From: Alfred Yeatman [REDACTED]
Sent: 25 August 2017 10:26
To: Simon Davis
Cc: Rachel Davies
Subject: RE: P/49/17/DOC Church Farm Holiday Village [NLP-DMS.FID263510]

Following further work to the Church Farm drainage scheme we attach updated drawings and associated calculations.

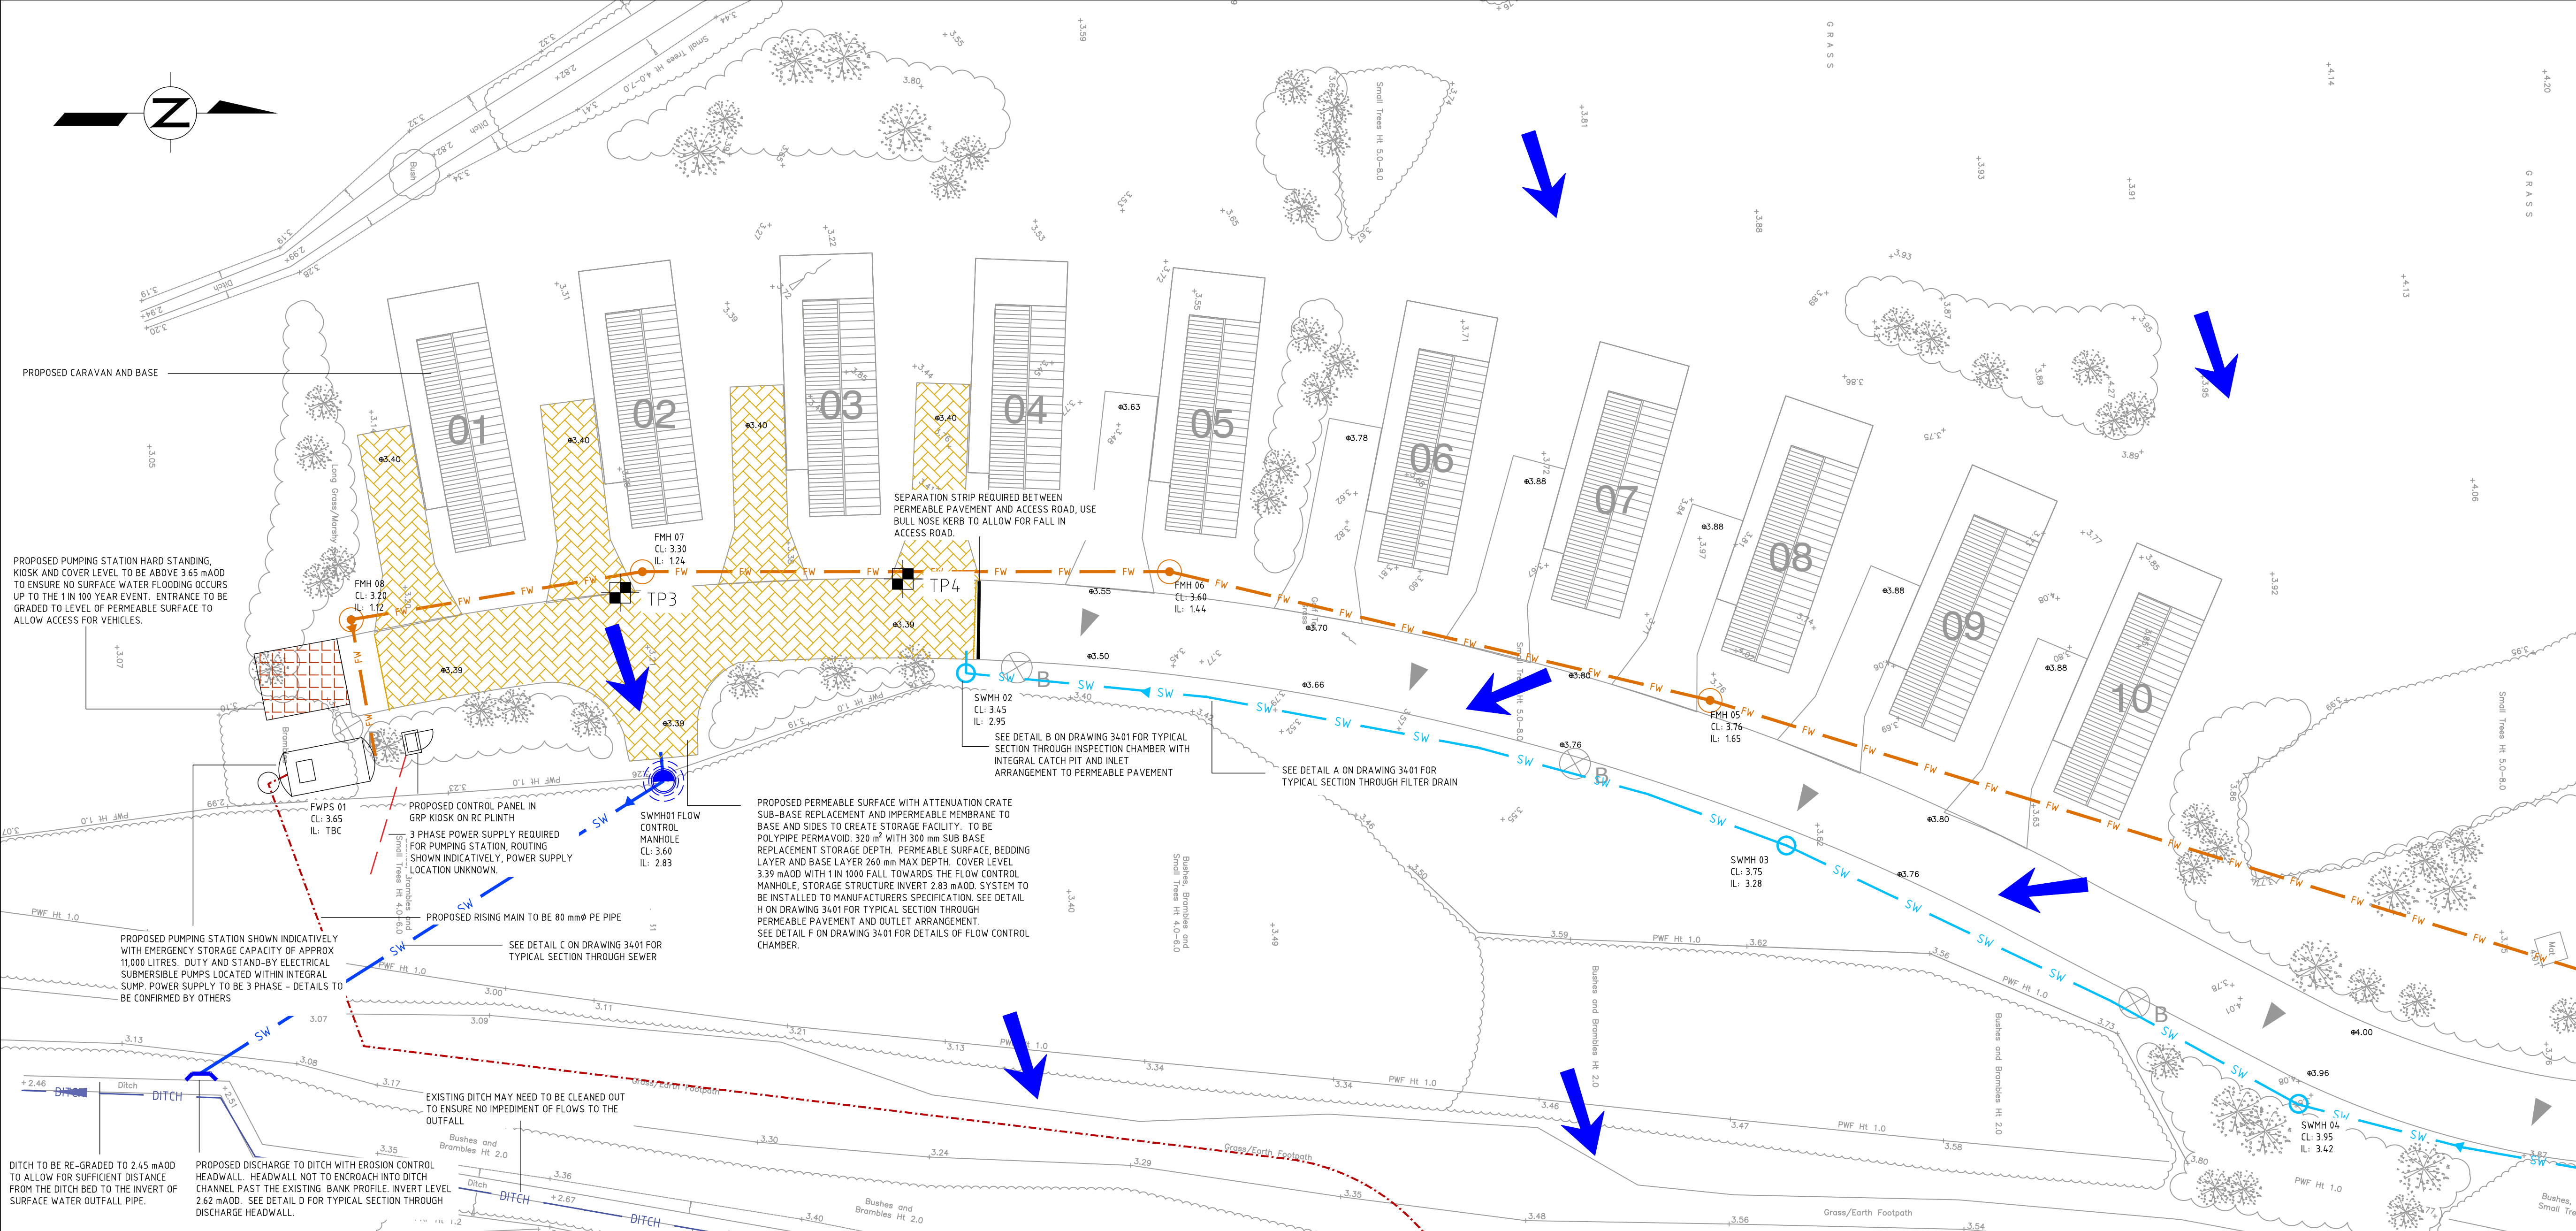
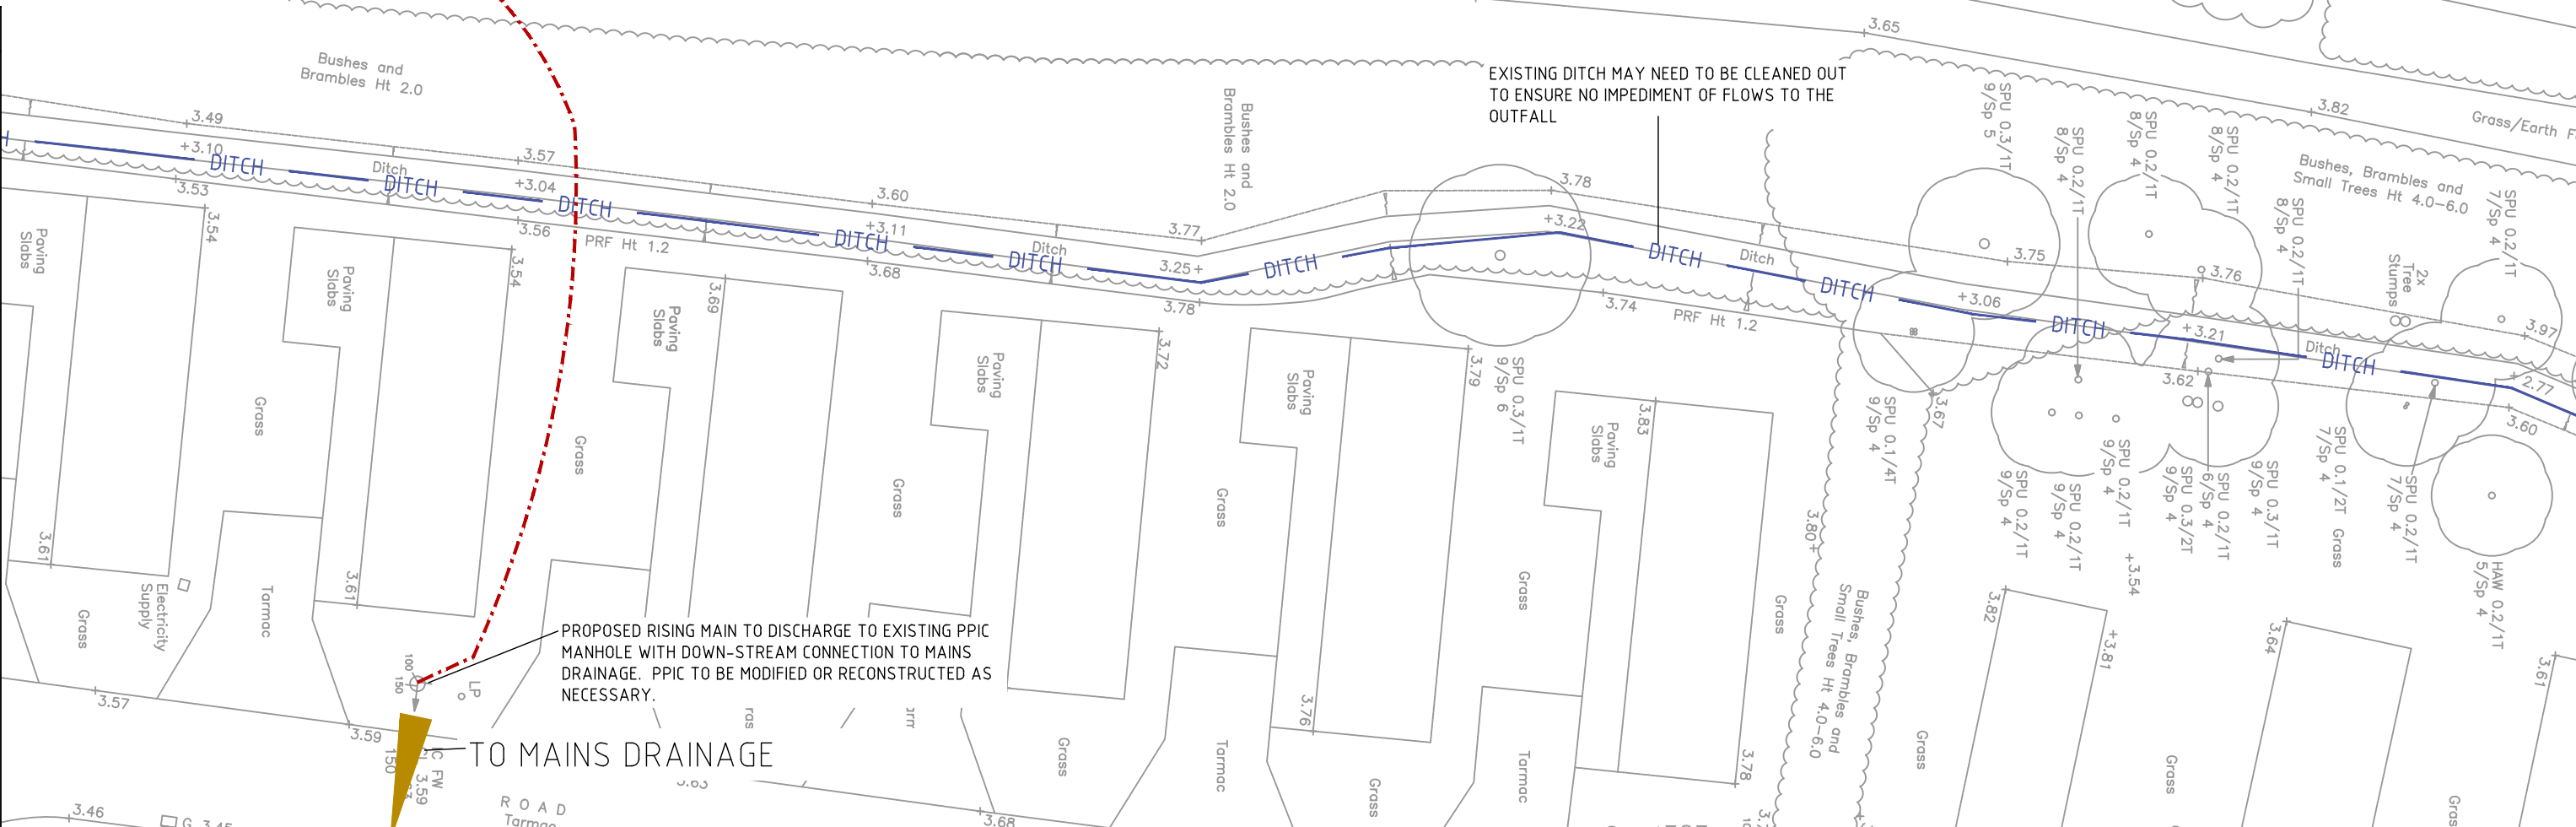
- 1. All manholes on filter drain to contain silt traps. Additional manhole access required. Ie. on heads of each system/at all significant changes of direction/at intervals not exceeding 50m. **See amendments to drawings 3001 and 3002.***

- 2. Show link on plan from southern most permeable pavement to control chamber. **See amendment to drawing 3002.***
- 3. Investigate invert of southern outlet pipe where it discharges to the ditch, in order to provide as much distance as possible between ditch bed and pipe invert. Re-grading the ditch may be an option if the design cannot be adjusted. **Not possible to lower invert due to available falls on site. Therefore ditch to be re-graded to lower level – see note on drawing 3002.***

- 4. Specify levels/gradient of filter drain. **See levels on drawings 3001 and 3002.***
- 5. Show finished surface levels for access road/permeable paving. **See levels on drawings 3001 and 3002.***

- 6. Existing ditch may need to be cleaned out to ensure no impediment of flows (add note to drawing). **Note added see drawings 3001 and 3002.***
- 7. Provide calculations to prove that excess water can be stored above ground (within the raised kerb area) during the 1 in 100 year storm event +30% allowance for climate change. **System has now been altered to allow for underground storage of flows in 300mm deep Permavoid structure, see MicroDrainage calculations for details. Note North catchment details have also been amended.***
